February 10, 2016

Project Name:	65 Munjoy Street Condominiums	Project ID:	2015-225
Address:	65 Munjoy Street	CBL:	003-M-5
Applicant:	Adams Apple, LLC		
Planner:	Nell Donaldson

8-unit Condominium Development
65 Munjoy Street
Level III Site Plan and Subdivision Review
2015-225
Adam's Apple LLC

Drawing file: plans / 12 A2 Preliminary Proposed Elevations_12_8_15.pdf

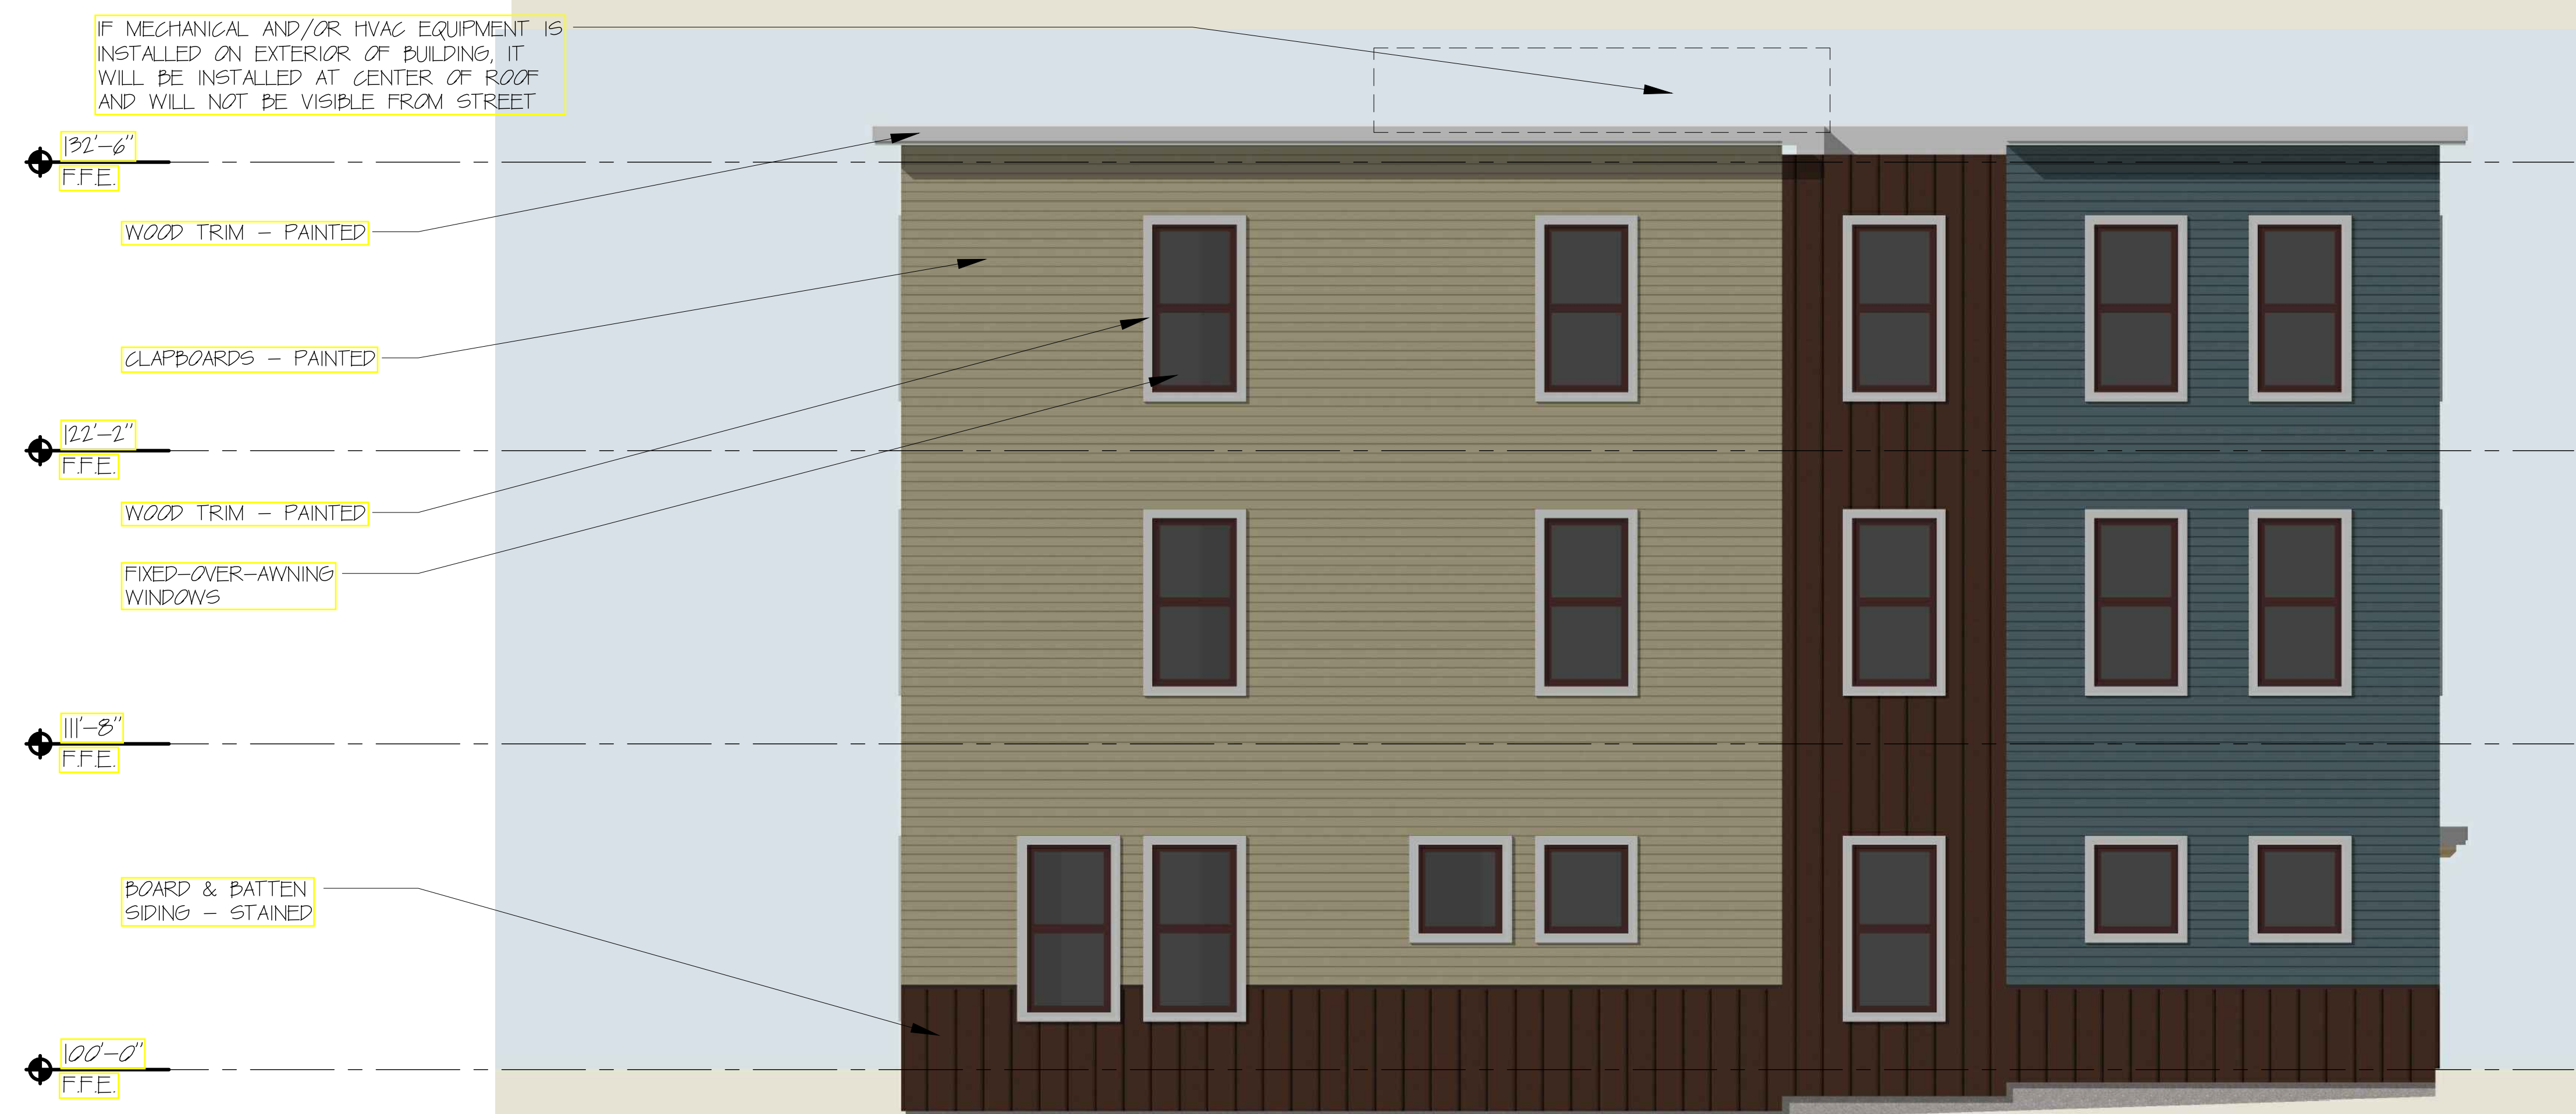
The preliminary architectural drawings submitted by the applicant for the purposes of site plan review remained relatively unchanged from the response to the RFP (*Plans 12 and 13*). In these drawings, the exterior of the building was designed to appear as two adjoining triple deckers, but the interior of the building was organized as an apartment building with three units on the upper two floors and two on the first. Based on a preliminary R-6 design review, staff suggested that the applicant move away from the triple decker exterior design concept in an effort to more accurately reflect the interior composition of the building and improve the quality of interior spaces. Staff suggested that the applicant add elements reflective of the neighborhood which might lend articulation, such as bay windows, and modify the proportions of the front porch. The applicant subsequently held their neighborhood meeting to gain feedback on the design. Revised plans were provided to the city in late January.
